April 23, 2008

**Re: Portland Museum of Art Site Plan Submission Response to Staff Questions
Spring Street Parking and Gardens**

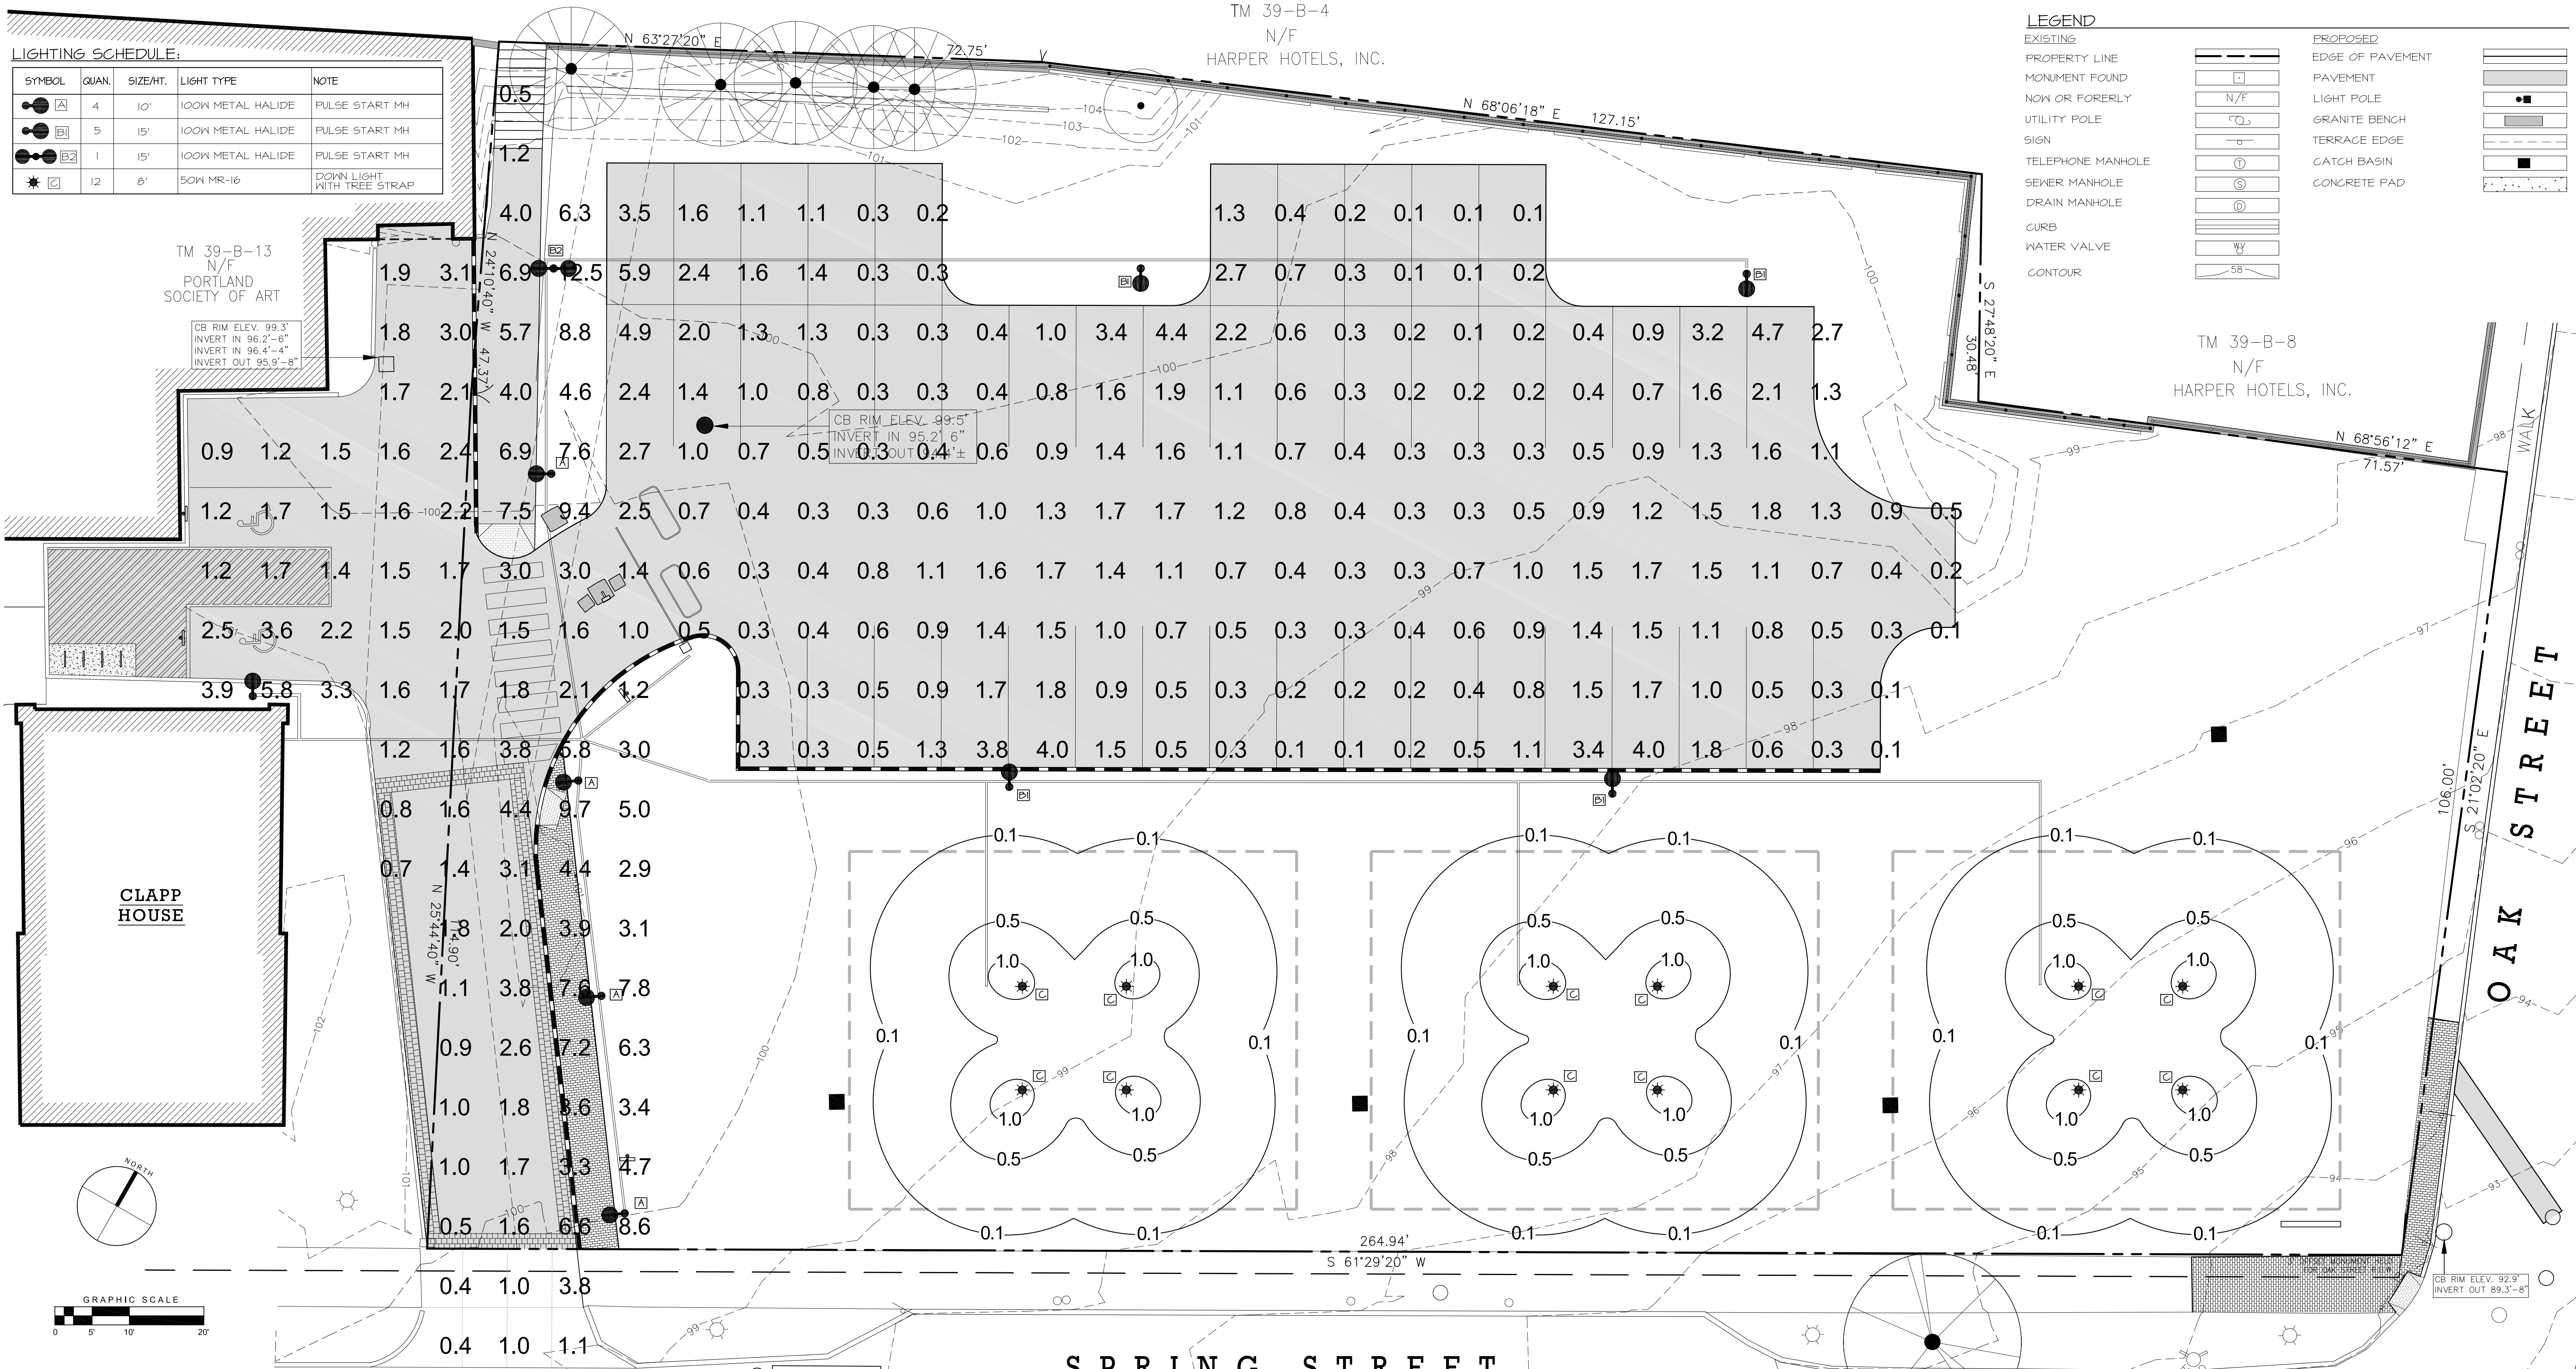
3. Proposed Site Lighting:
The photometric plan that was prepared and submitted on April 11, 2008 for the lighting for the project provides safe and sufficient light levels for the use of the parking based upon our discussions with the Museum, our experience, and generally accepted lighting standards for parking lots. As can be seen in the summary chart on drawing L2.1 there is an average level of 1.02 footcandles in the parking lot and the

minimum to maximum light range falls within the range of 0 fc to 6.9 fc. There are three locations within the parking lot where the illumination level is considered low at a level of 0.1 fc. It is our opinion that these isolated areas of lower light levels will in fact be sufficiently illuminated due to the lighting sources adjacent to this property, including illumination from the Holiday Inn on Spring Street. It is our intent to request a waiver from the Planning Board for any areas of nonconformity with the City's Technical Standards because the Museum does not want to create excessive light levels in this part of their property.

1 FENCE AT CONCRETE RETAINING WALL AND STEEL TRELLIS (ALTERNATE #1): WEST SECTION  
 L5.3 SCALE: 1" = 4'

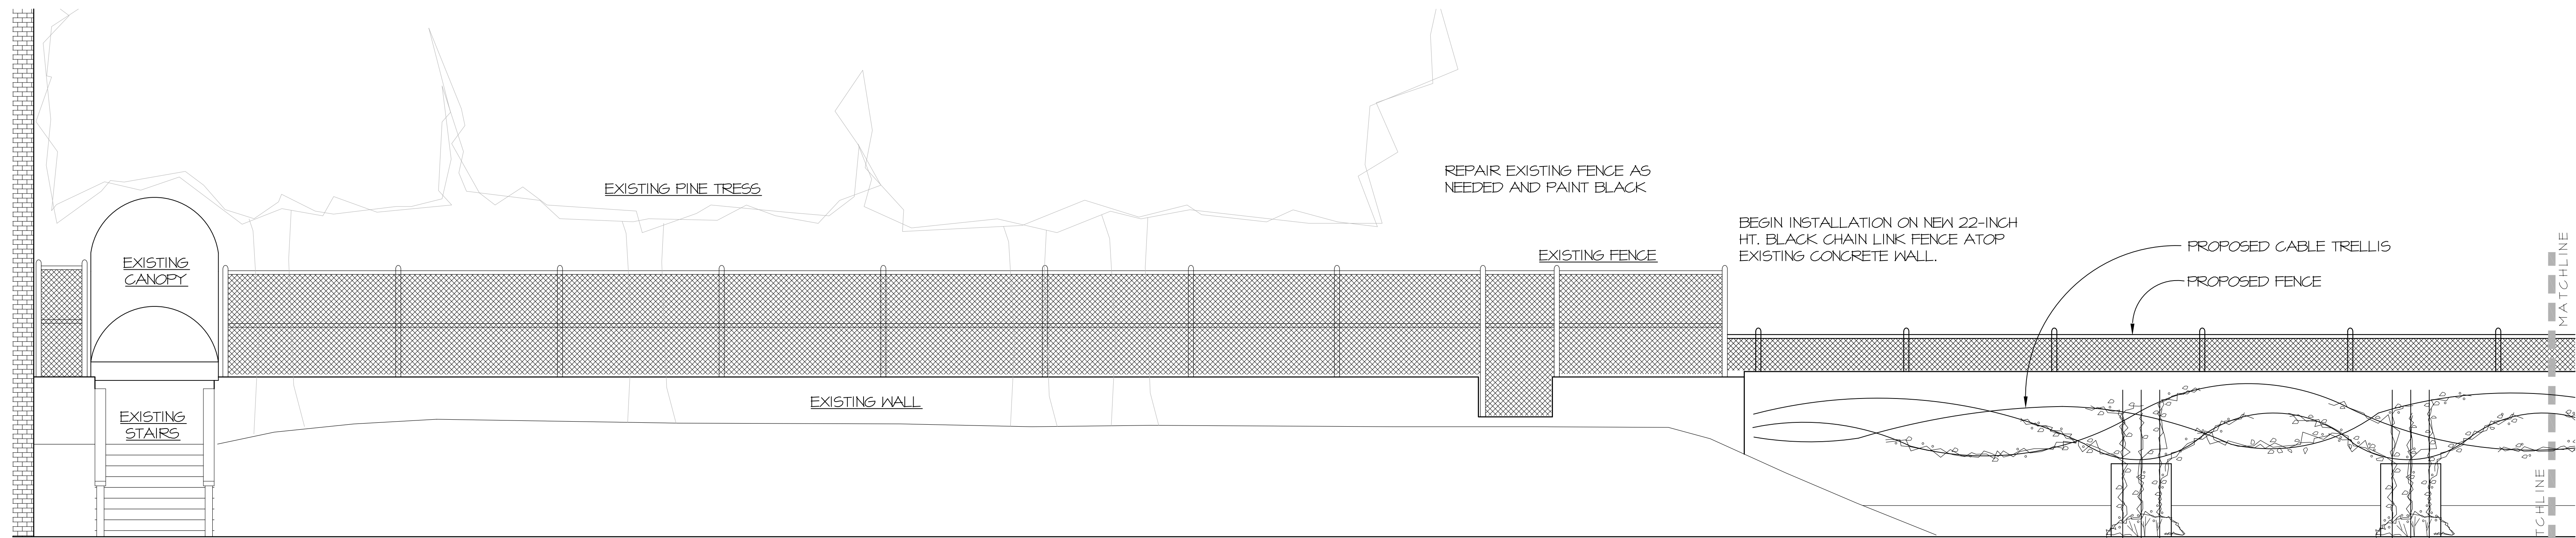
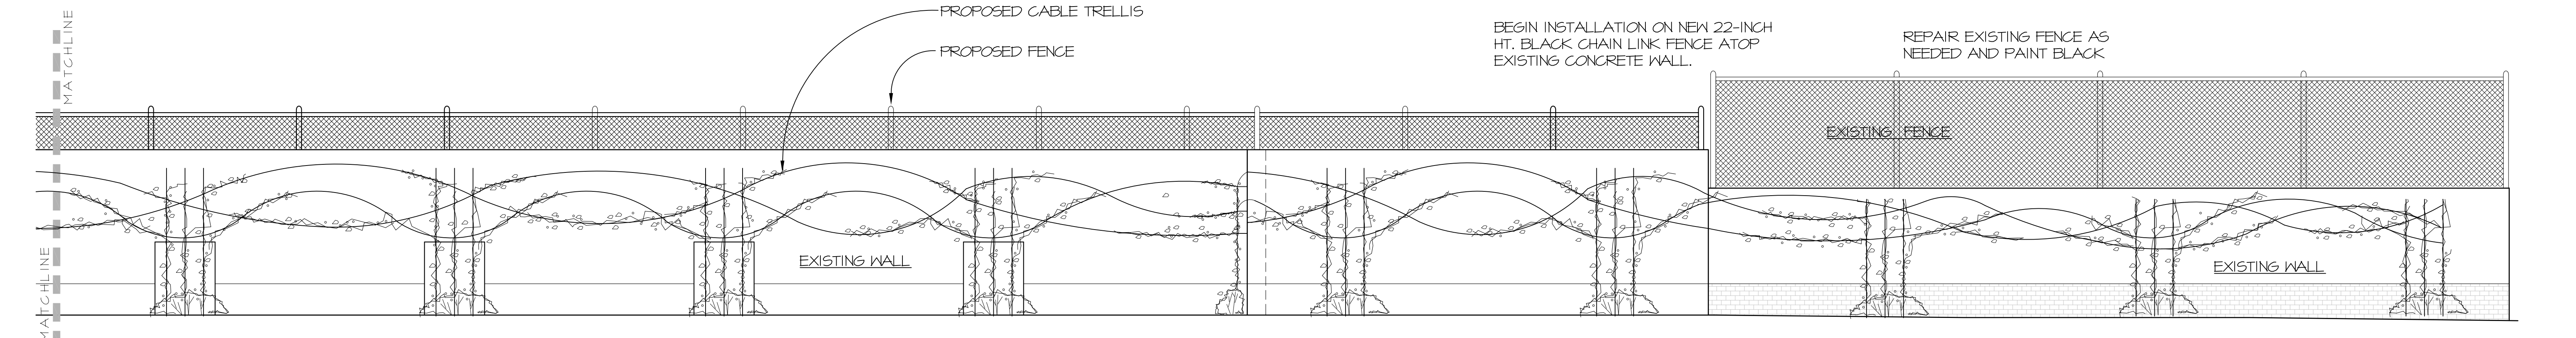
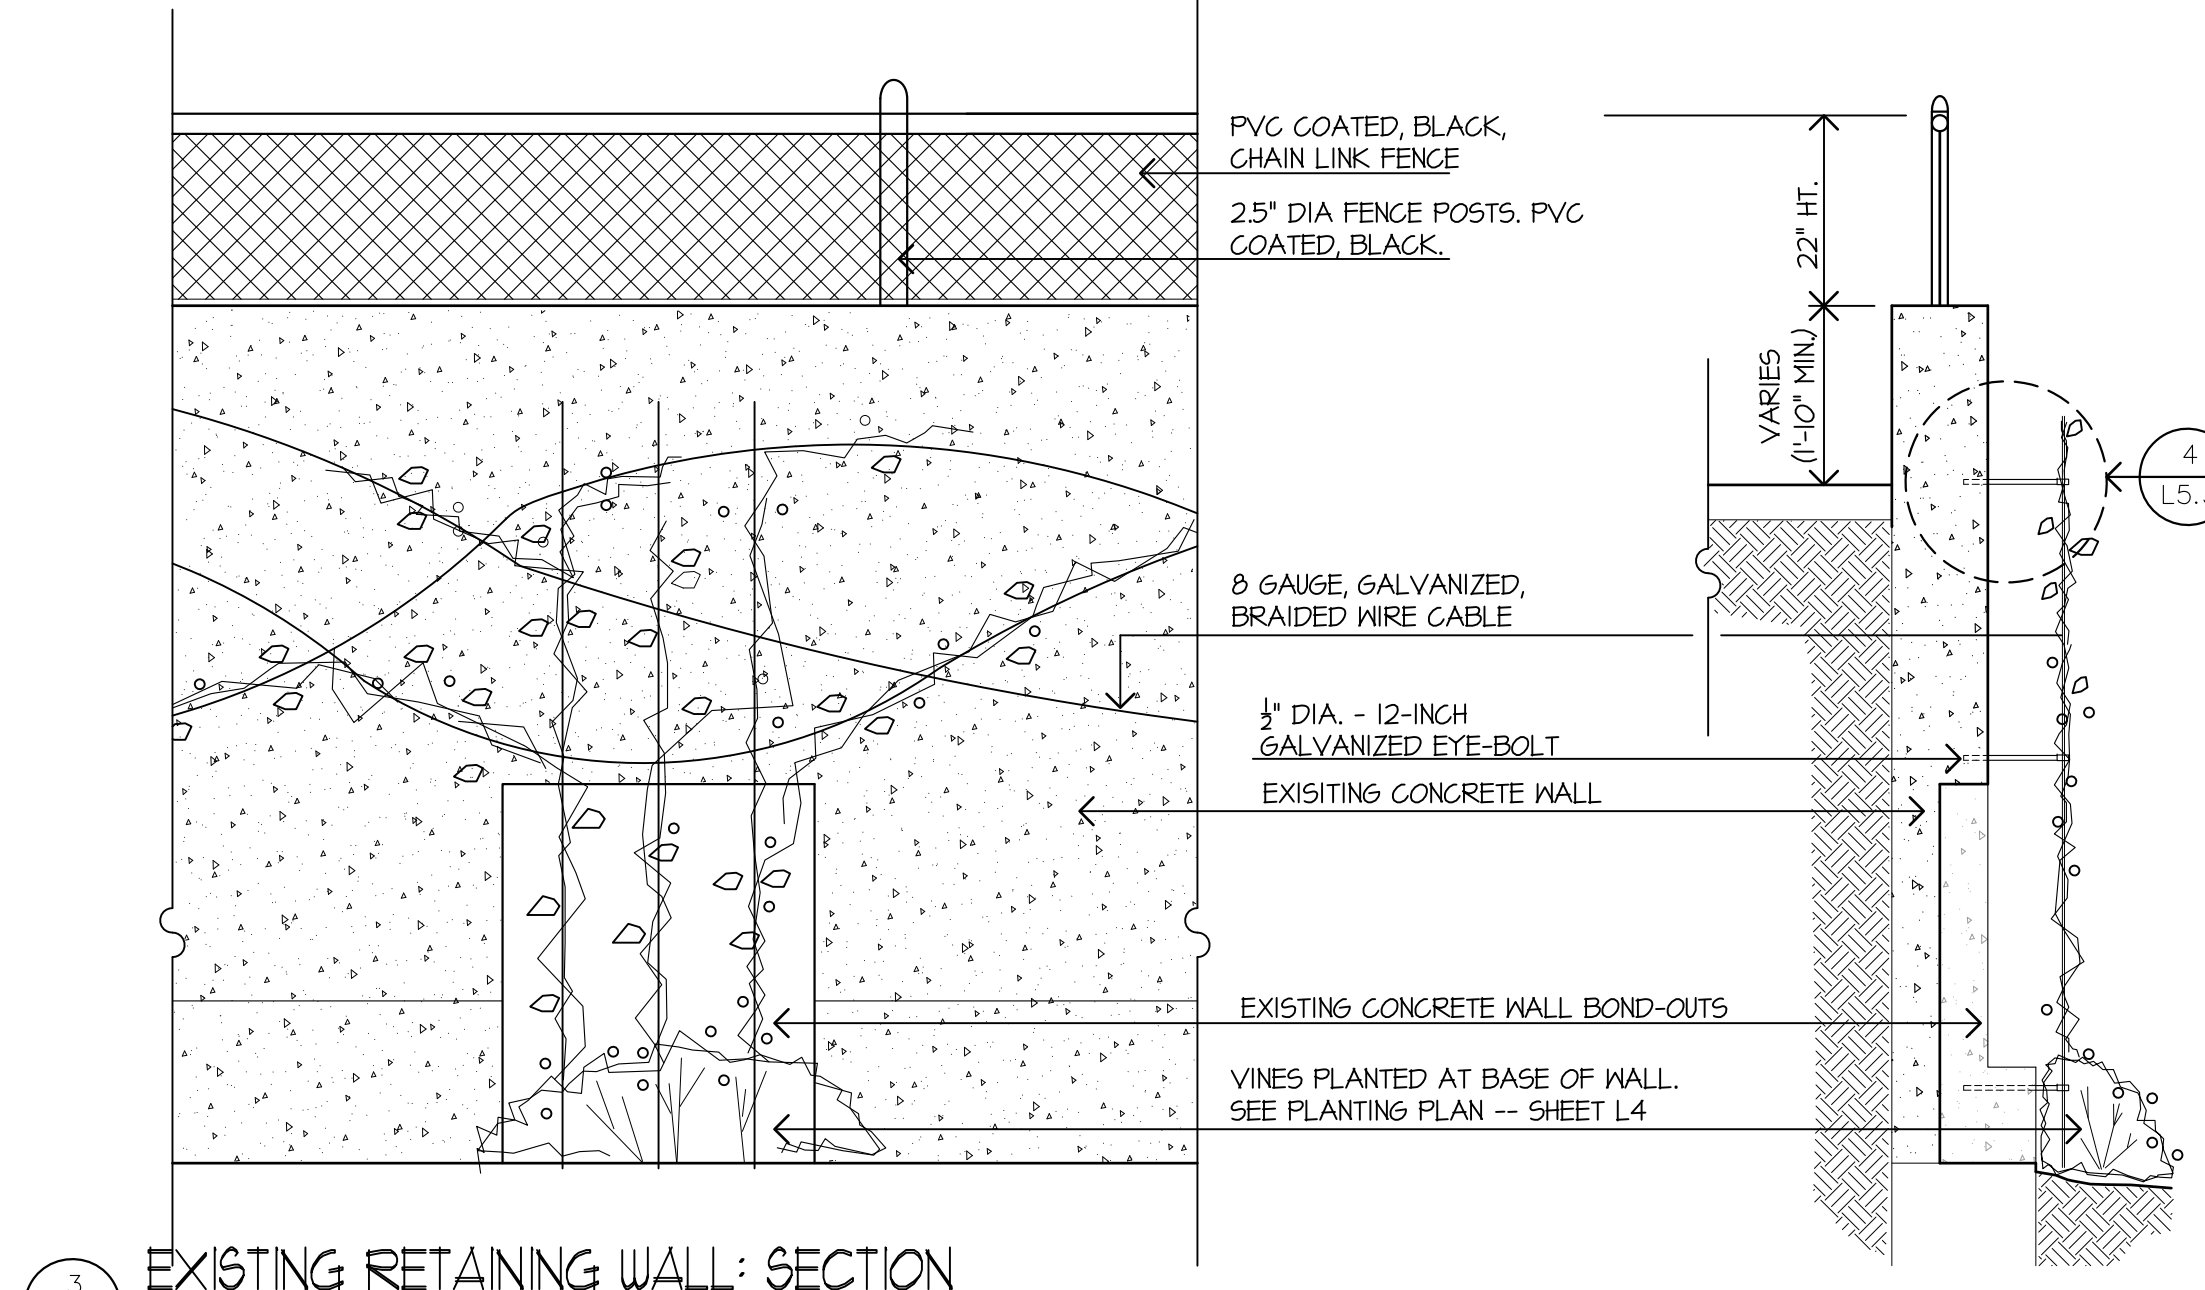
2. Trellis and Wall Fence Details:
Our initial submission I indicated that the existing concrete wall would have trellises attached to it at 10' intervals on part of the wall. On top of the wall sections of the existing chain-link fence will be preserved, but new 22" high chain-link fence will be installed where a temporary chain-link barrier has been placed. In the supplemental submission made to the department on April 11, 2008 we included a section of the wall showing these improvements on drawing L5.2. At the time of the workshop we will provide additional graphics that further define the design of both the trellis and the new fence.
